COUNTY COUNCIL'S RESPONSE TO CONSULTATION ON THE FOLLOWING DEVELOPMENT PROPOSAL

Application no: 18/00904/F

Proposal: Formation of inland waterways marina with ancillary facilities building, car parking, access and associated landscaping including the construction of a new lake

Location: Glebe Farm, Boddington Road, Claydon, Banbury, OX17 1TD.

Fig 7.12.

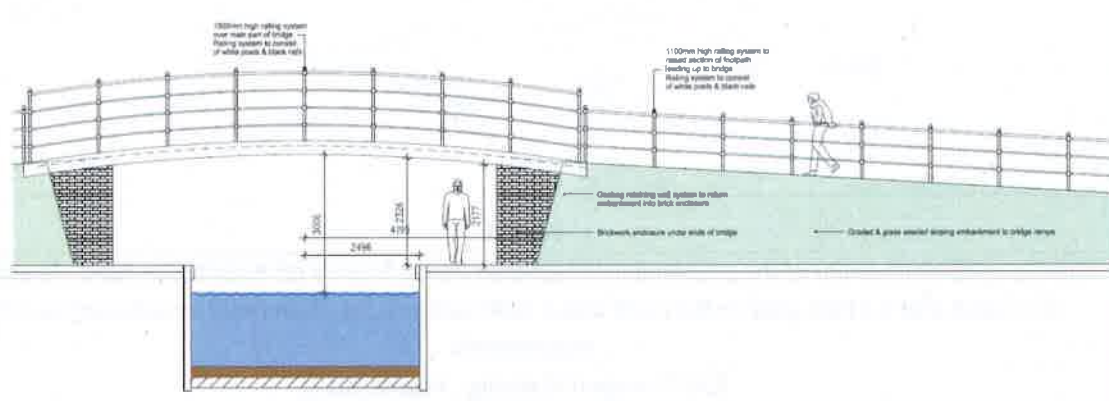
The proposed footbridge should be constructed to DMRB standards, or to Canal and River Trust (C&RT) public towpath standard. This structure must be maintainable by the applicant or C&RT and OCC accepts no liability for its construction, public liability or future maintenance. The footpath/towpath will need to be closed to enable construction and a temporary closure needs to be applied for from OCC. Note that there is normally a 12 week lead time for this. It is expected that the footpath/towpath will be protected from plant damage and repaired to same or higher standard after the works have been completed.

**Proposed Highways Access**  
Scale 1:200

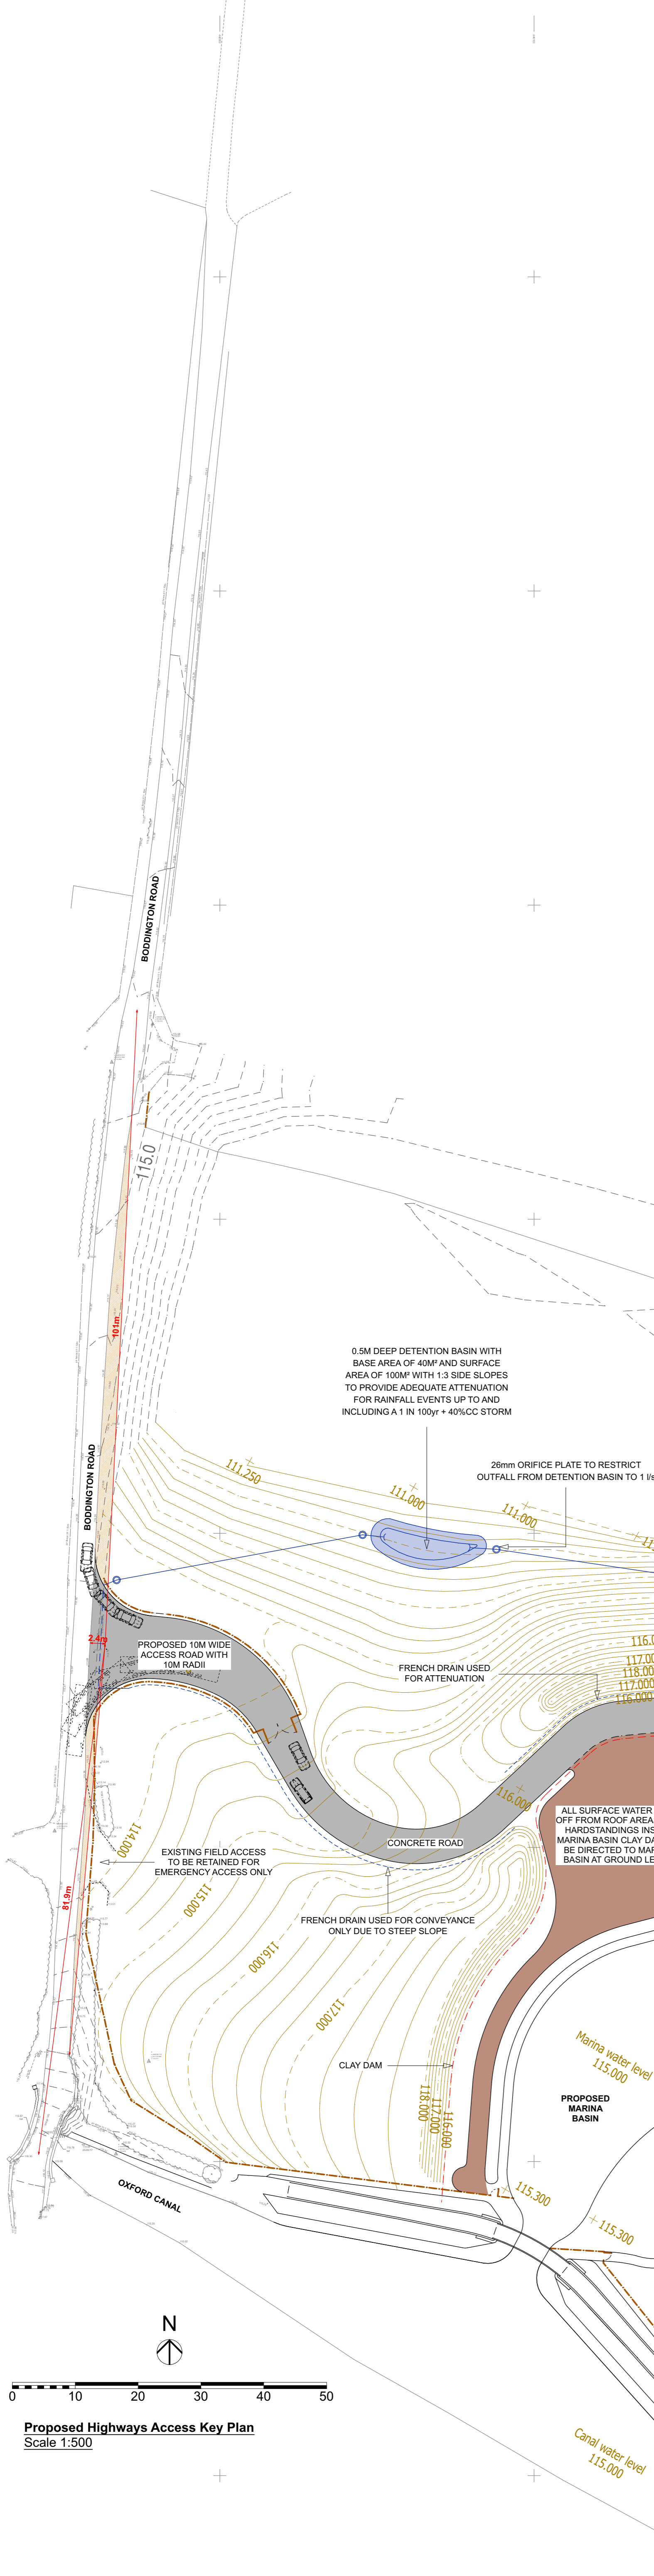
From a recent site visit, I am not convinced that the required visibility splays are achievable for a national speed limit road. It might be the case that vegetation will need to be significantly cut back to allow for the required splays to be achieved. I however agree that due to the physical constraints of Boddington Road such as the hump back bridge south of the site and the carriageway being single track traffic speeds are generally low.

The established road network from Banbury Road (Boddington Road in particular) and from the A423 (Fenny Compton Road) that gives access to the site have substandard visibility and width constraints along. The TA supporting the application fails to recognise this fact but does not even suggest a safe solution for those likely to access the site. Boddington Road runs for about 2km from Banbury Road in the north to the site access and serves not only the proposed Marina but some residential and farm properties as well.

Prior to the commencement of the development hereby approved, full details of the means of access between the land and the highway, including, position, layout, construction, drainage and vision splays shall be submitted to and approved in writing by the Local Planning Authority. Thereafter, the means of access shall be constructed and retained in accordance with the approved details.

Fig 7.12.

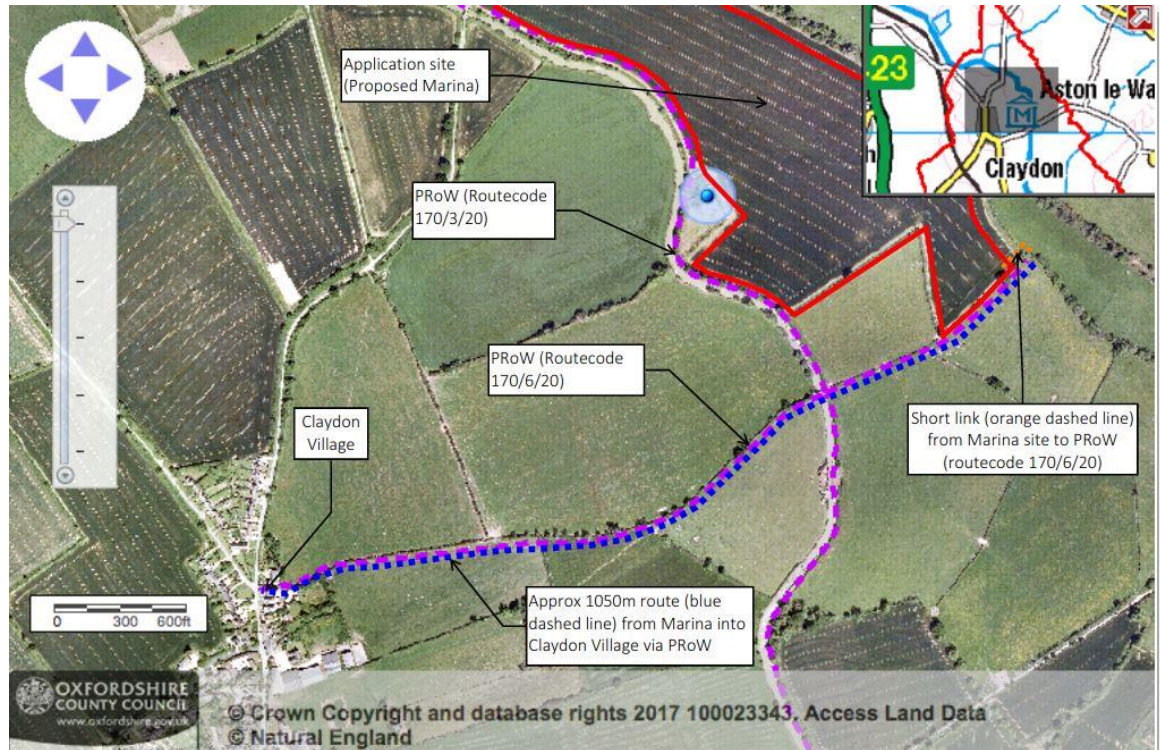
The applicant should fund improvements for the footpath to Claydon to enable visitors/residents to gain access. A sum of £10k is considered appropriate for spot surface, furniture (stile to gate replacement) and vegetation management works
